Town & Country Planning Act 1990 (as amended)
Town and Country Planning (Development Management Procedure) (England) Order 2015
Approval of details reserved by condition imposed under FG/39/18/PL relating to conditions 3-
surface water drainage, 4-ground contamination risk, 9-position & intensity of lighting filments, 14-
lighting scheme, 15-Construction Management Plan & 16-ground contamination risk.
Garage Premises Littlehampton Road,Ferring,

Arun District Council have decided to **REFUSE details reserved by condition for the following reasons:**

FIGURE 2: INVESTIGATION LOCATION PLAN

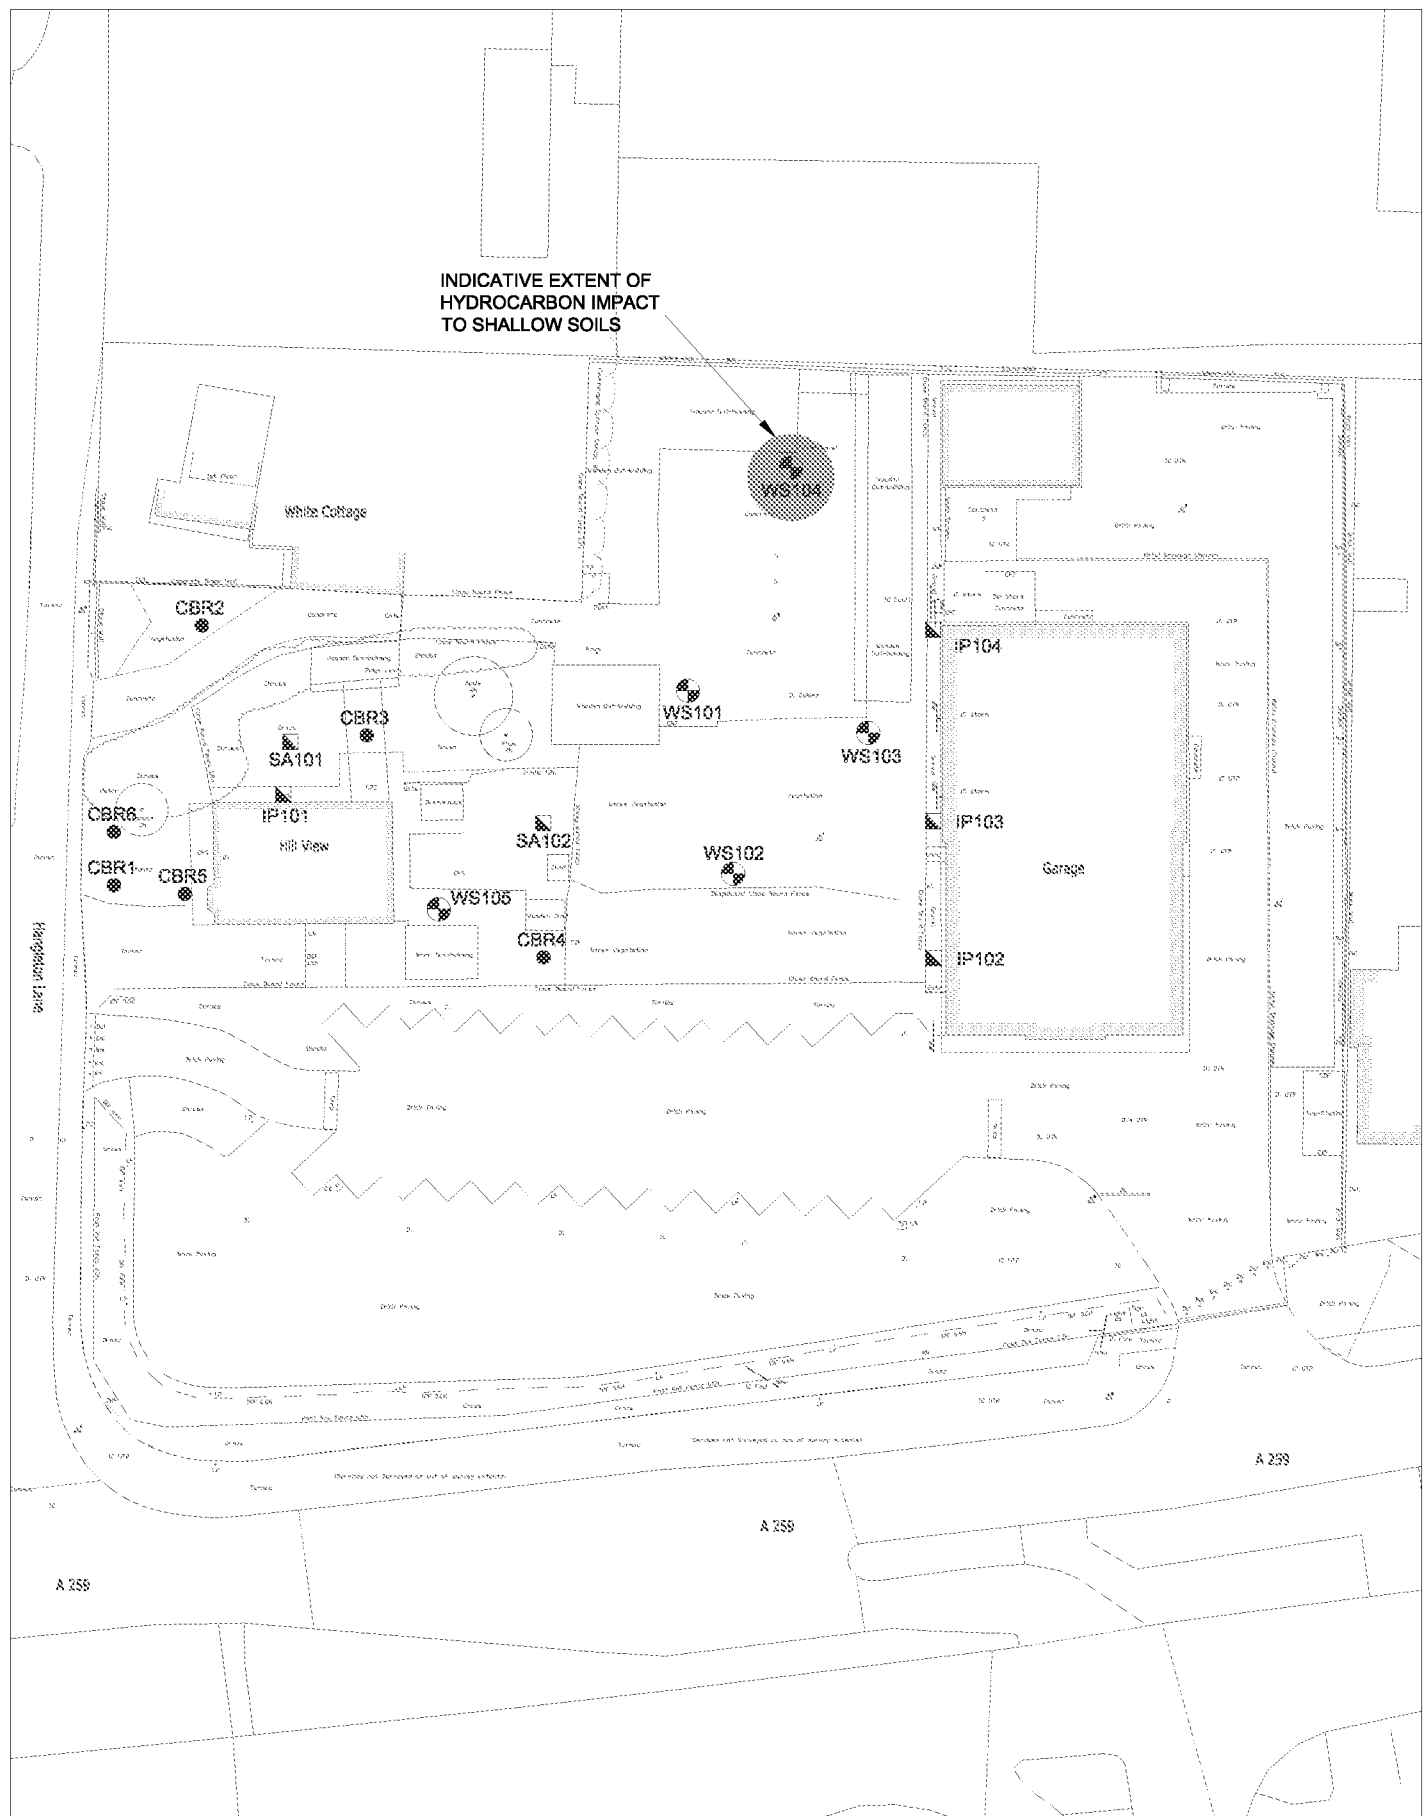
This condition is refused on the basis that the Ground Condition assessment (J18-035-R02). identifies localised hydrocarbon contamination in the vicinity of WS104 and hydrocarbon odour in WS103. Section 5.2.3 states that groundwater locally has been slightly impacted with hydrocarbon contamination already and that as concentrations in the soil are low this does not represent an ongoing source. However no samples have been taken between WS104 and WS103 and groundwater samples have not been reported.

Therefore further investigation to determine the extent of the impact in soils and groundwater around WS104 and the hydrocarbon odours observed in WS103 is required. This should be incorporated into the conceptual model and then a remediation strategy and subsequently a verification strategy submitted (if required).
